Our Ref: WA/106/20/DOC

Approval of details reserved by condition imposed under ref WA/22/15/OUT relating to Condition Nos 6 - materials & finishes, 10 - hard & soft landscaping, 11(a) - protection of retained trees, 12 - surface water drainage, 14 - maintenance & managements of SuDs, 15 - foul drainage and 20(d) - forecourt layout, drainage, position & intensity of lighting fitments.

Arun District Council have decided to **REFUSE details reserved by condition for the following reasons:**

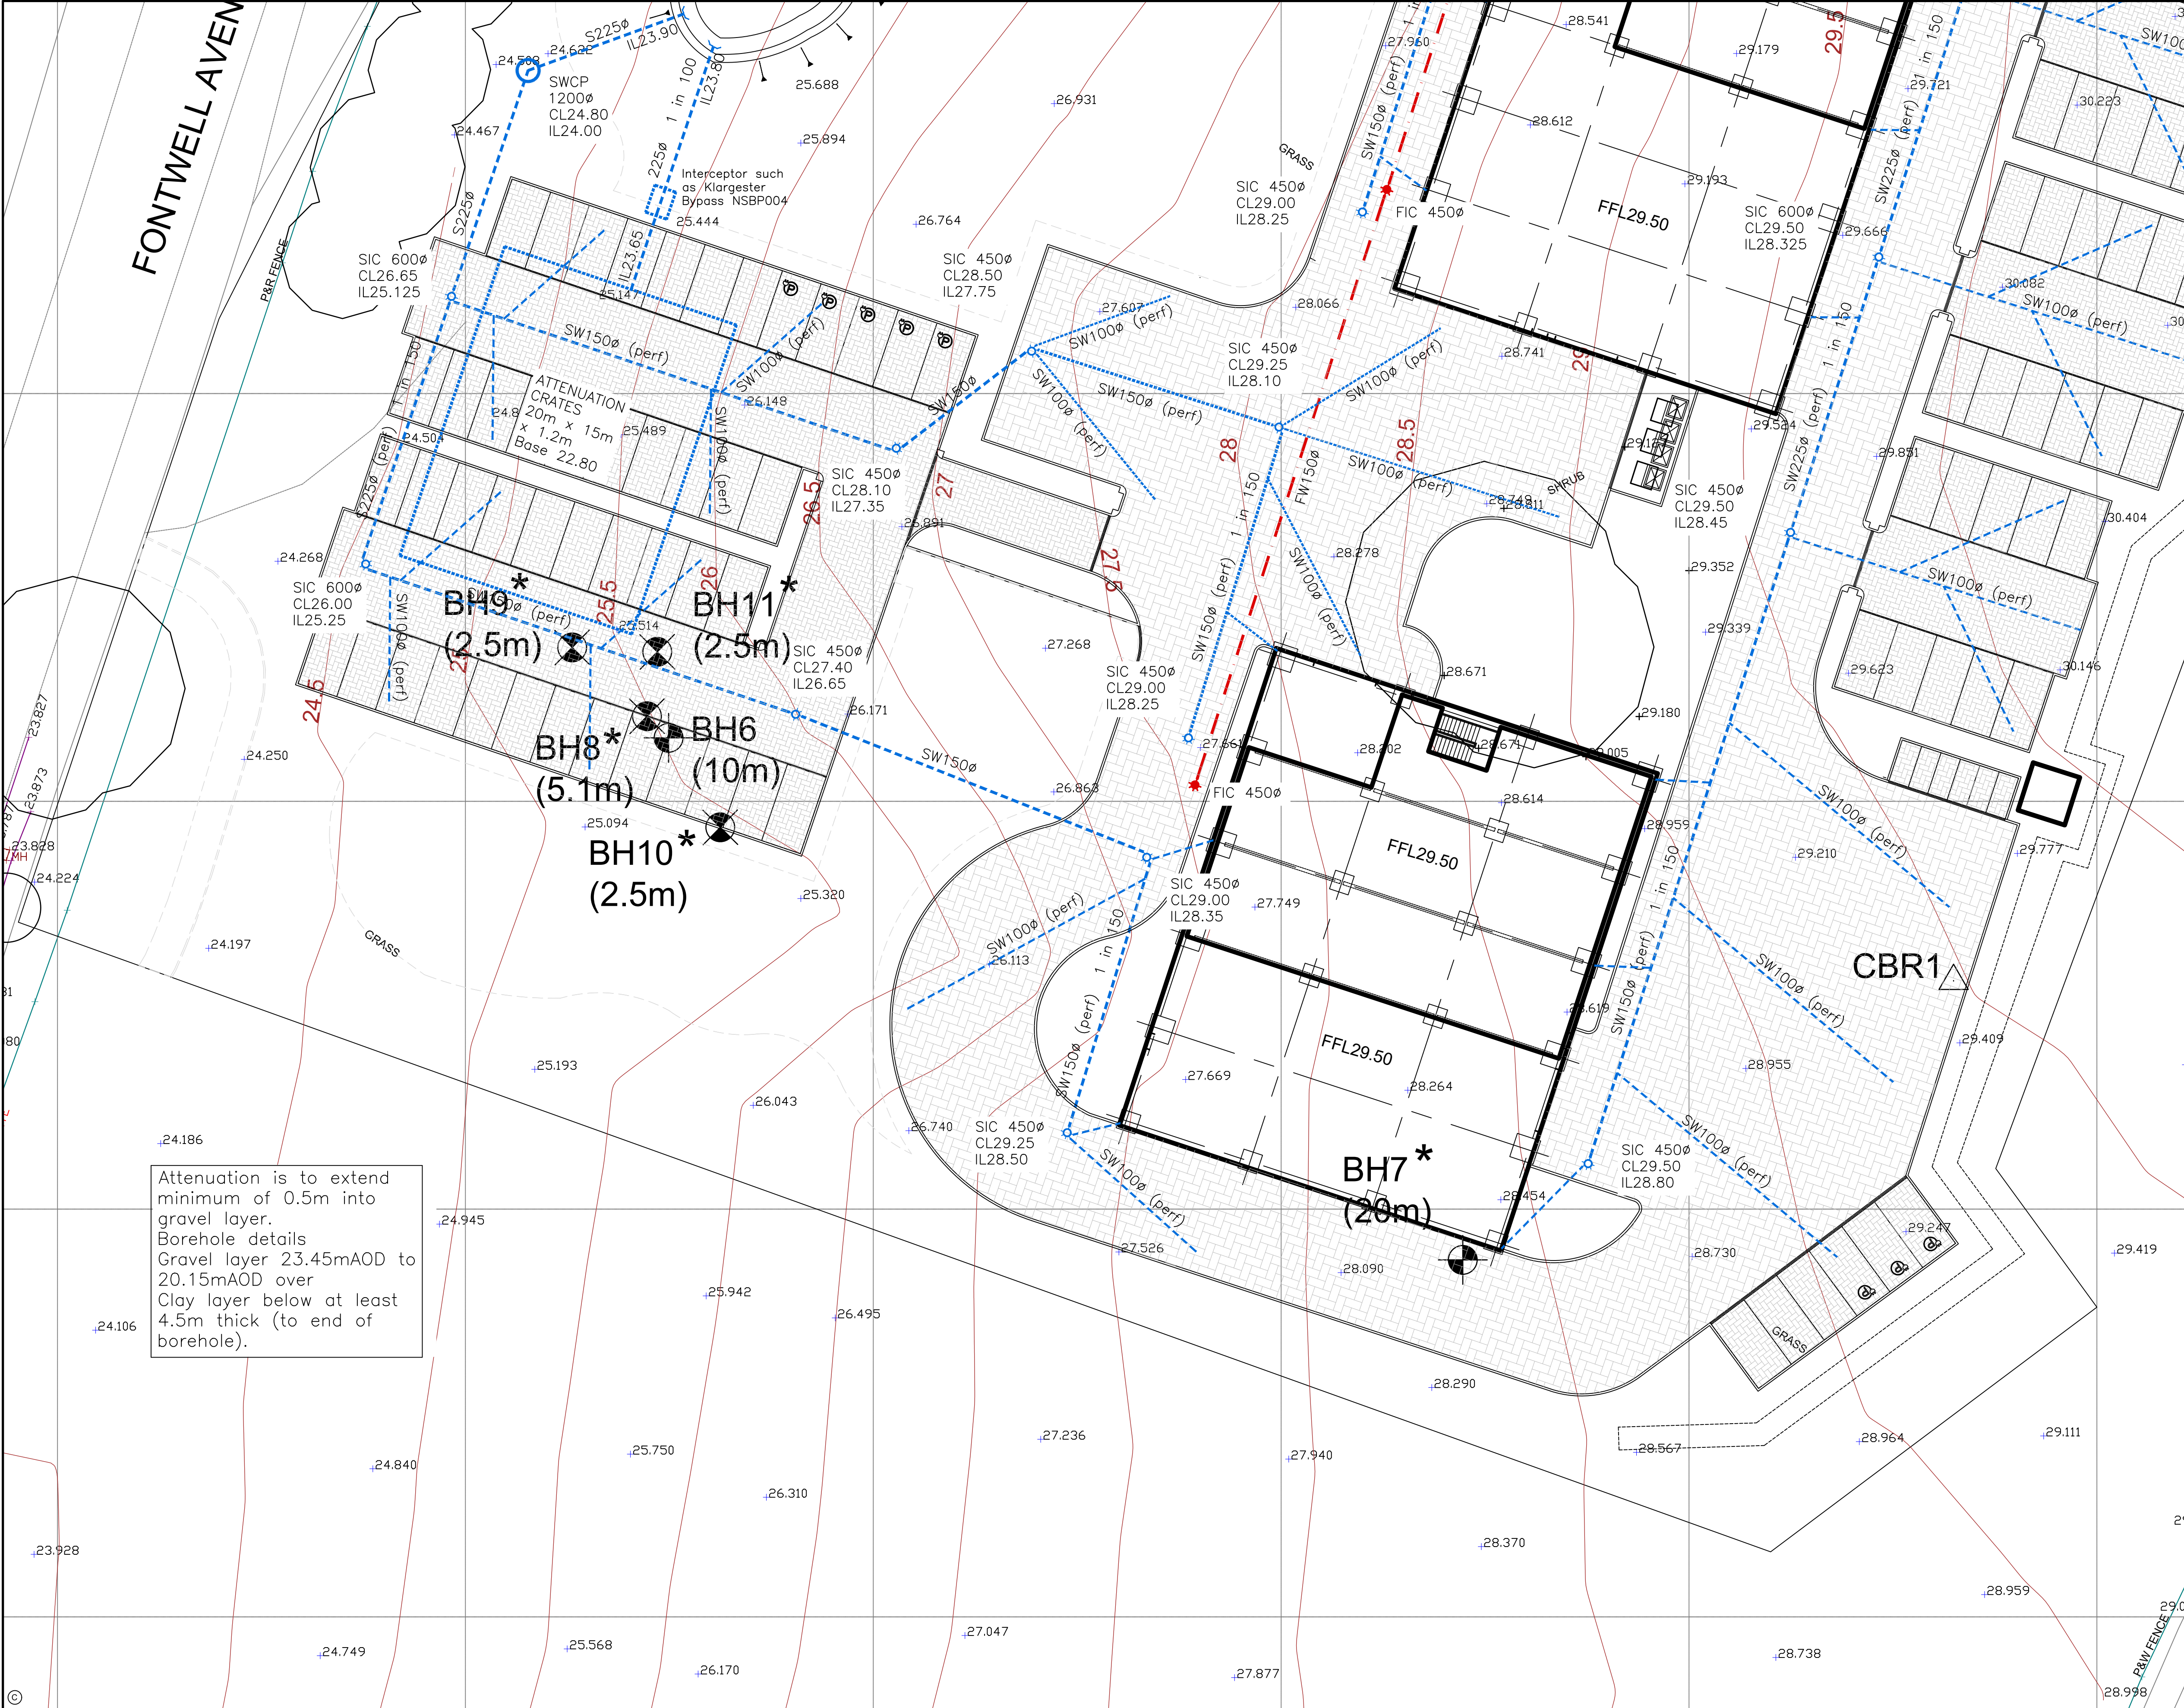
The forecourt is an integral part of the site and insufficient information has been submitted to demonstrate that the site will be satisfactorily drained.

A detailed drainage strategy for the light industrial area is required, including details of the type of drainage basin (attenuation or infiltration), details of the SW connections, SW outfalls (discharge points) and the level of water quality treatment must be suitable for the land use (B1 (b)/(c)) with reference to the CIRIA SuDS Manual.
